CHERWELL DISTRICT COUNCIL

Appeal by Mr Geoffrey Richard Noquet against Cherwell District Council's failure to give the requisite notice of its decision in relation to a retrospective application for change of use from public house (sui generis) to hotel/bed and breakfast (Class C1) at The Pheasant Pluckers Inn Burdrop, within the appropriate 8-week determination period.

Appeal Site: The Pheasant Pluckers Inn, Street Through Burdrop, Burdrop

Planning Inspectorate Reference: APP/C3105/W

FLOOR PLAN

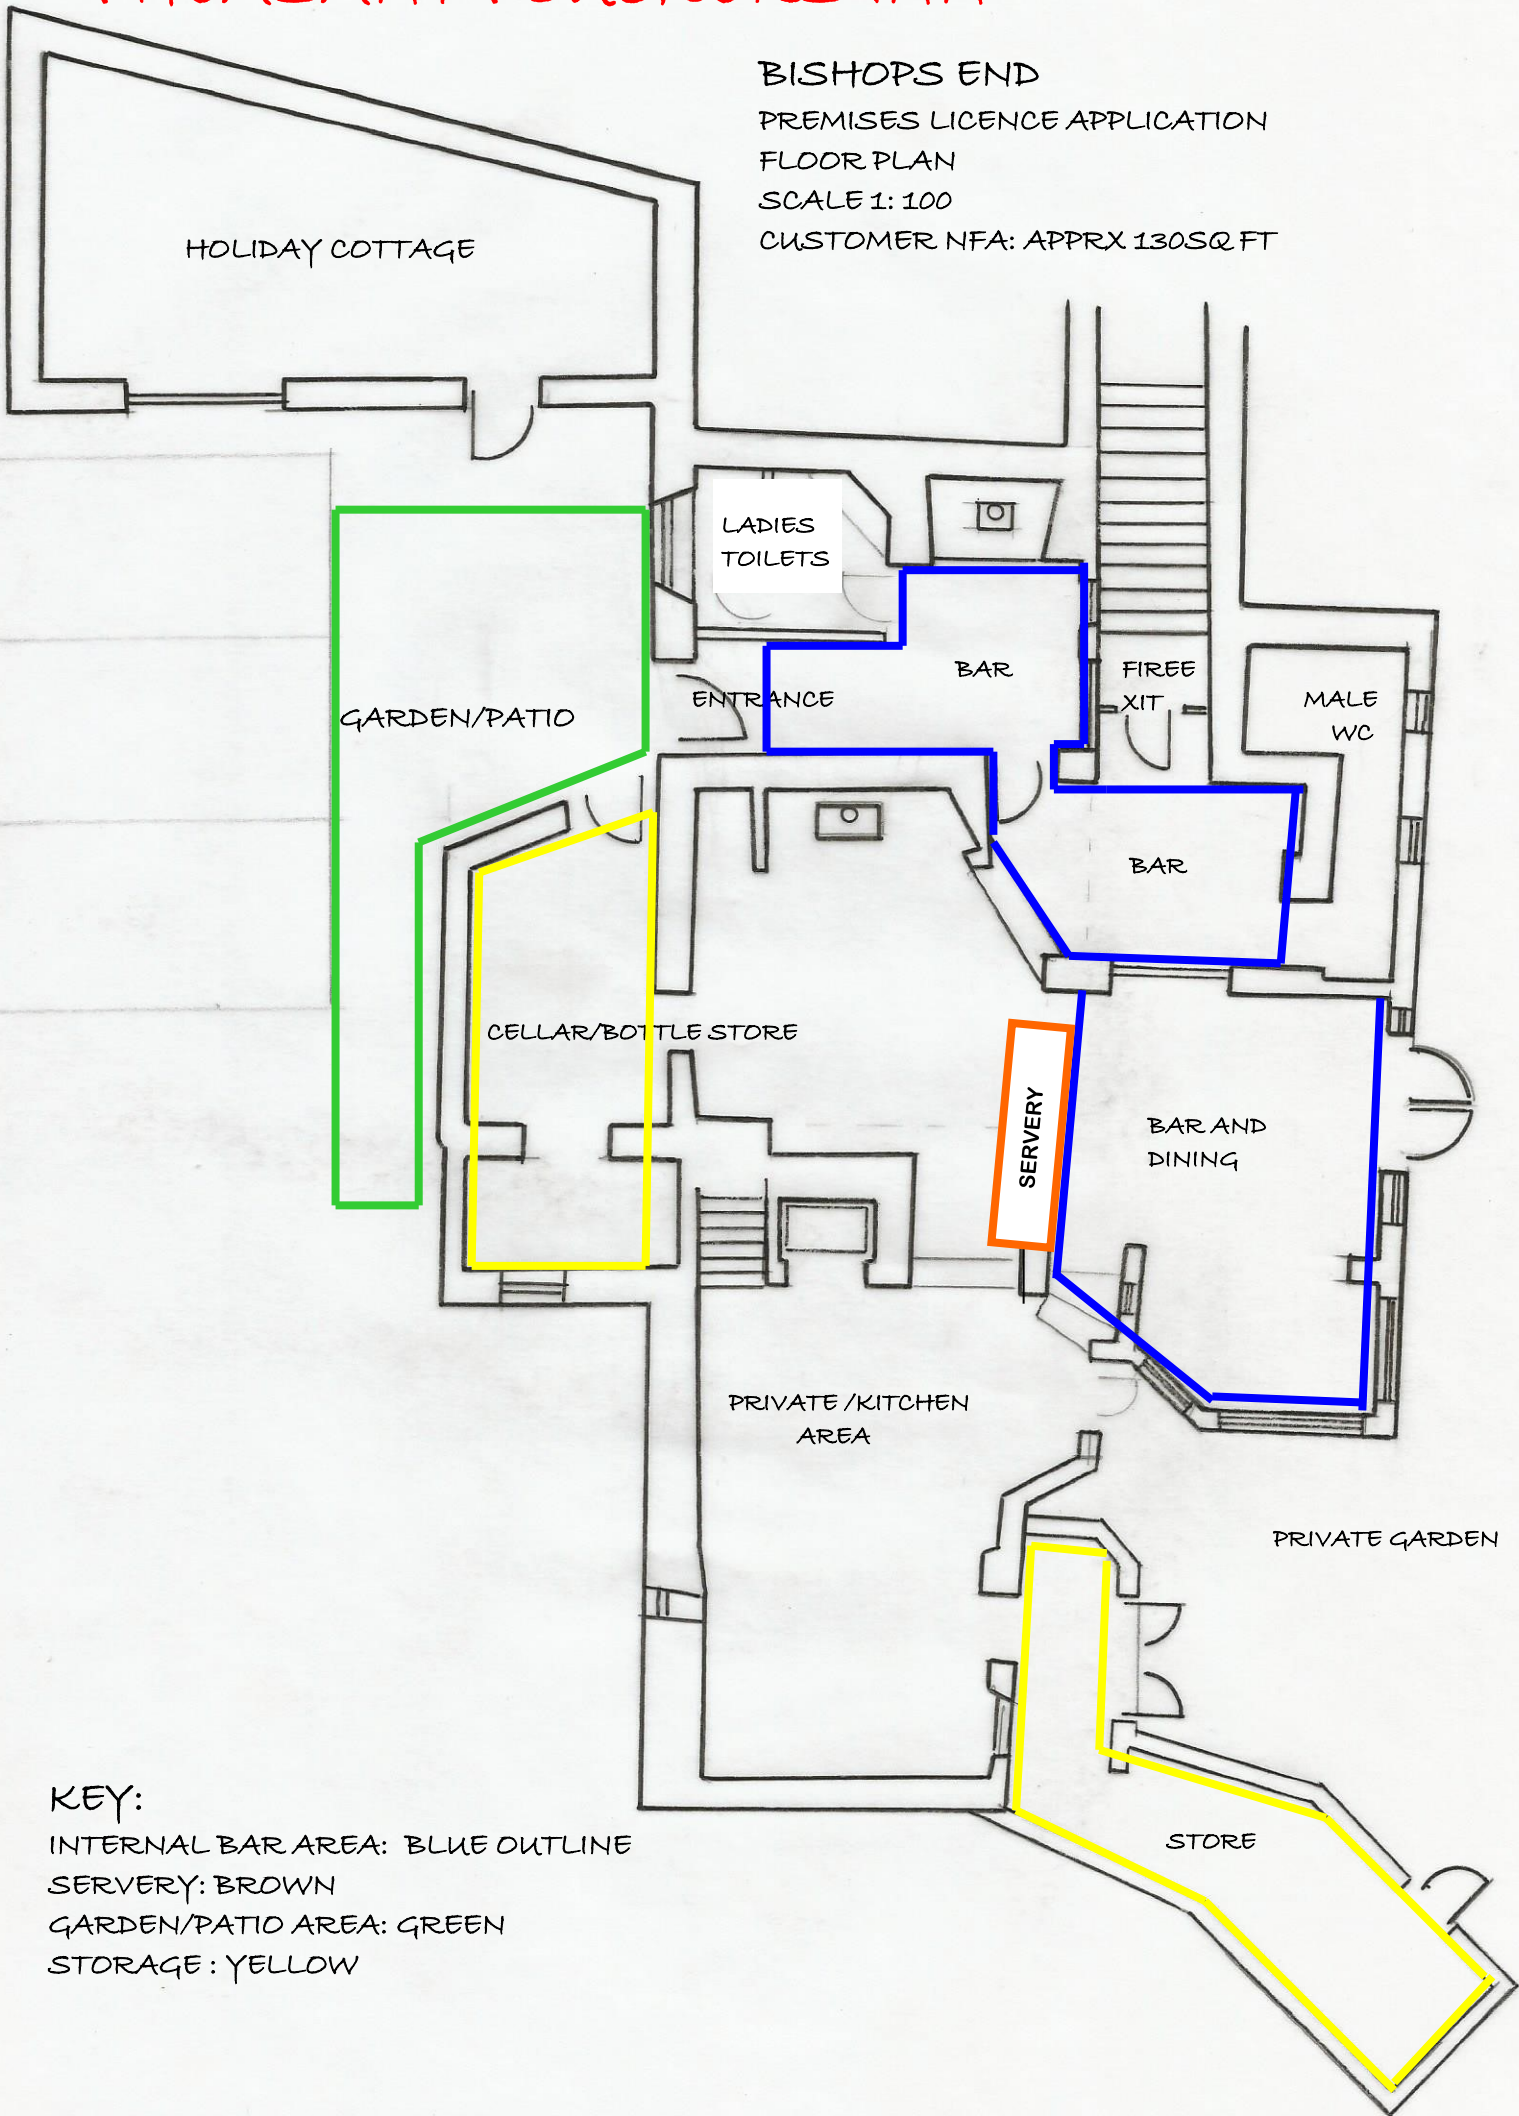
- 1.8. Subsequent to the original submission (13.03.23), the Council received a ground floor plan of the premises (05.04.23), which annotates the existing use of the space at ground floor level, without explaining or referring to how the ground floor space would be used under the appeal proposal.

- 1.9. The Council submits that an acknowledgment letter was sent out to the Appellant in error. The Council submits the application/appeal is invalid, as the proposal does not include floor plans or elevations (both proposed or existing) to demonstrate the change of use, and how the building would be used for the purposes stated in the application form.

- 1.11. The Appellant states that he does not intend to alter the existing building, and that the floor plans would not be altered to facilitate the proposed change of use. However, there are no details to show how the rooms on the first floor would be used for the purposes of a hotel or bed and breakfast.

- 1.12. Without the first floor plans, or a clear explanation of how the internal floor space at ground or first floor would be used, it is simply not possible for the decision maker to make a full and proper assessment of the appeal proposal.

3. Prior to the first use or occupation of the building for the purposes hereby approved, detailed floor plans to show the location of the guest accommodation and living accommodation and to show how all other internal floor space would be used shall be submitted to and approved in writing by the Local Planning Authority. The development shall not be carried out other than in strict accordance with the approved details.
